Application Reference: 2025/0978

Site Address: 78 Long Causeway, Monk Bretton, Barnsley, S71 2JA

Introduction: Erection of rear flat roof dormer window and two storey rear extension.

DRAWING TITLE
 Existing &
 Proposed Plans

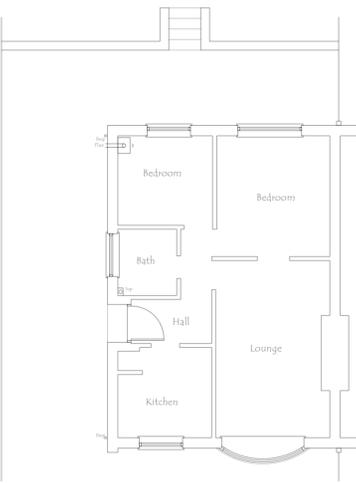
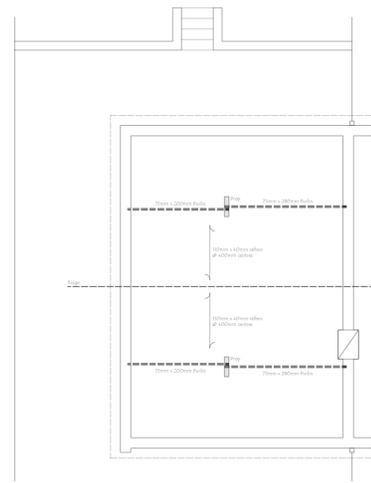
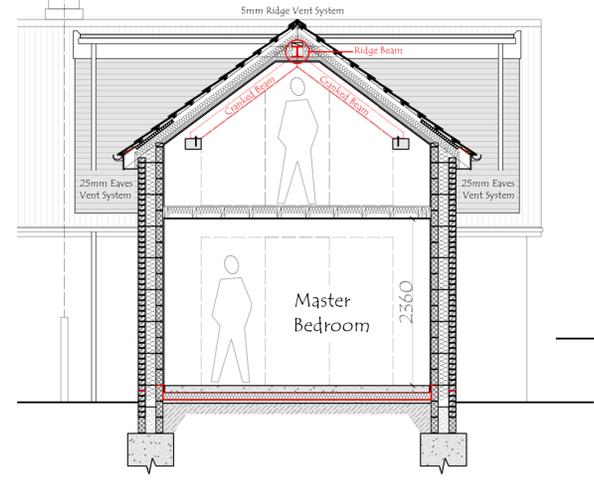
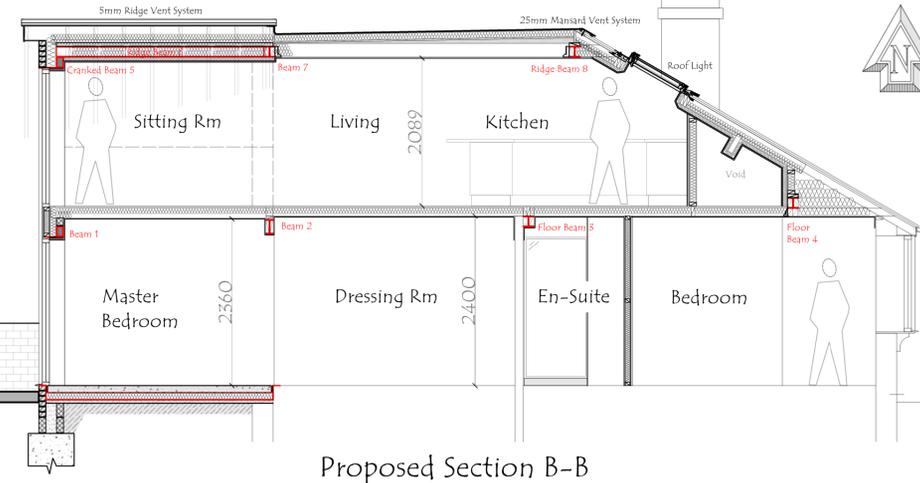
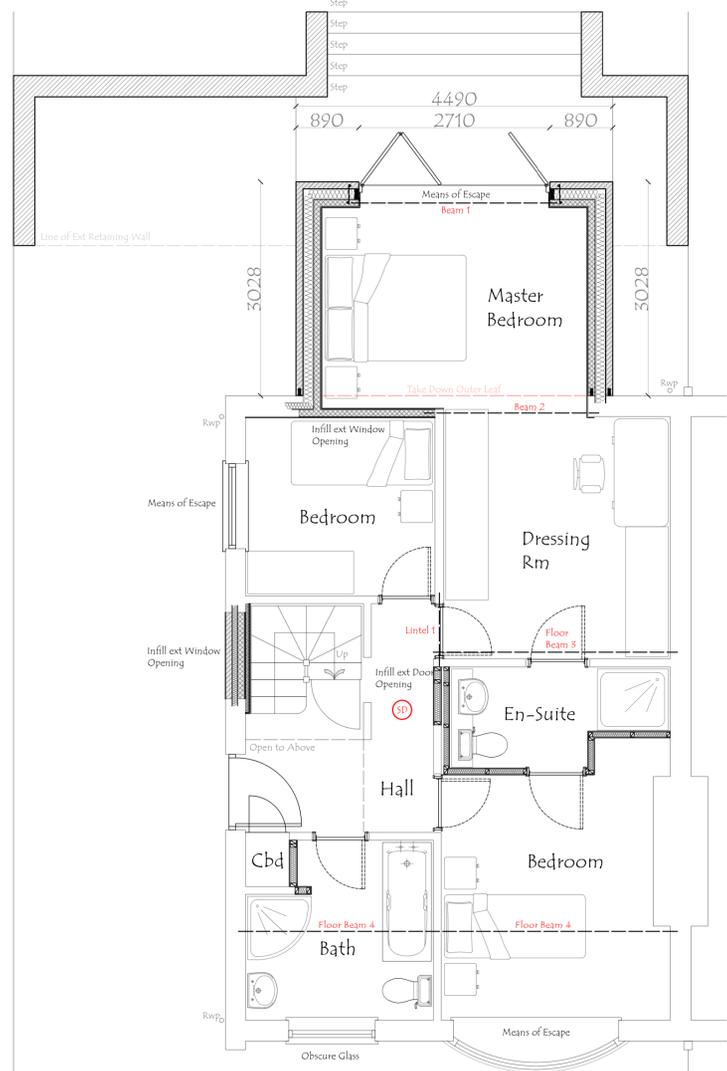
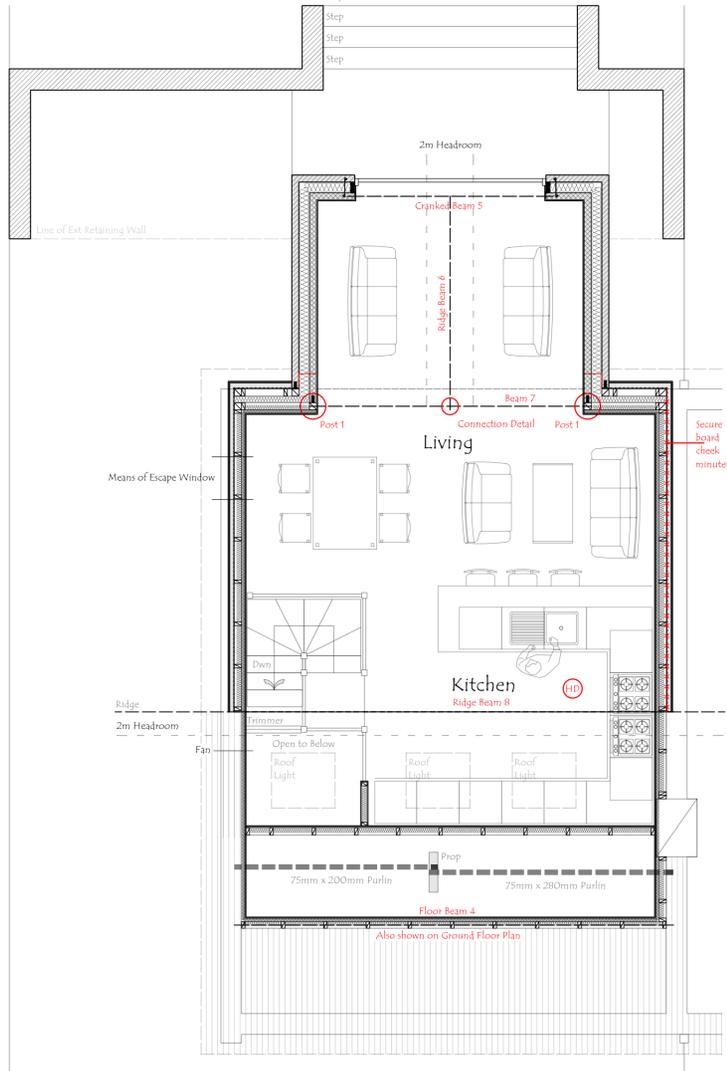
It is also acknowledged the dormer is to the rear of the dwelling and is of a similar design to other rear dormers in the street scene. However, the proposed rear dormer is not set in from the gable elevation or the adjoined neighbouring property by at least 0.5 metres. The dormer also provides a flat roof which is not preferred however is similar to other flat roofed dormers in the area.

The proposed two-storey rear extension with a gable roof would be attached to the rear elevation of the proposed rear flat roofed dormer. Whilst the two storey extension provides an acceptable rearward projection of less than 3.5 metres, the use of a gable roof form adjoining a flat roofed dormer on the existing pitched roof does not provide a design which is considered acceptable. The design would result in differing roof heights which would be to the detriment of the dwellings' character. As the existing dwelling has a pitched roof, the use of three different roof types and especially the gable roof form adjoining the flat roofed dormer is considered an unsympathetic addition to the dwelling which is out of character with the surrounding area and would provide a poor precedent. Additionally, the glazing proposed to the rear elevation is not considered to be in keeping with the existing fenestration of the dwelling. The use of matching materials is acknowledged and is to the proposals benefit but does not mitigate the unacceptable design of the proposal.

In addition, paragraph 139 of the National Planning Policy Framework expects poorly designed proposals to be refused. 'Development that is not well designed should be refused, especially where it fails to reflect local design policies and government guidance on design, taking into account any local design guidance and supplementary planning documents which use visual tools such as design guides and codes.' In this case the use of three differing roof types and two differing roof height is considered poor design.

The proposed two-storey extension would project approximately 3 metres to the rear of the dwelling. Although the extension is compliant with the House Extensions SPD in terms of rearward projection, the extension is to south of 76 Long Causeway resulting in impactful levels of overshadowing. No side elevation windows have been detailed facing the north and significant boundary treatment is in place, preventing any opportunity for detrimental overlooking. The south facing cheek of the proposed dormer does detail a window, however this would service a non-habitable living room and is therefore not considered to provide any detriment to the residential amenity of 80 Long Causeway. Although the proposal would provide overshadowing to the north, the proposed projection is compliant with House extensions SPD for the projection of a two storey rear extension to a semi-detached dwelling.

In the opinion of the local planning authority, the proposed rear dormer and two storey extension provides an unsympathetic scheme of poor design which would detract from the character of the dwelling to a detrimental degree. Consequently, this application is considered to be contrary to para 139 of the NPPF, and Local Plan Policy D1: High Quality Design and Place Making of the Local Plan which states that 'development is expected to be of high quality design' and 'complement and enhance the character and setting of distinctive places'
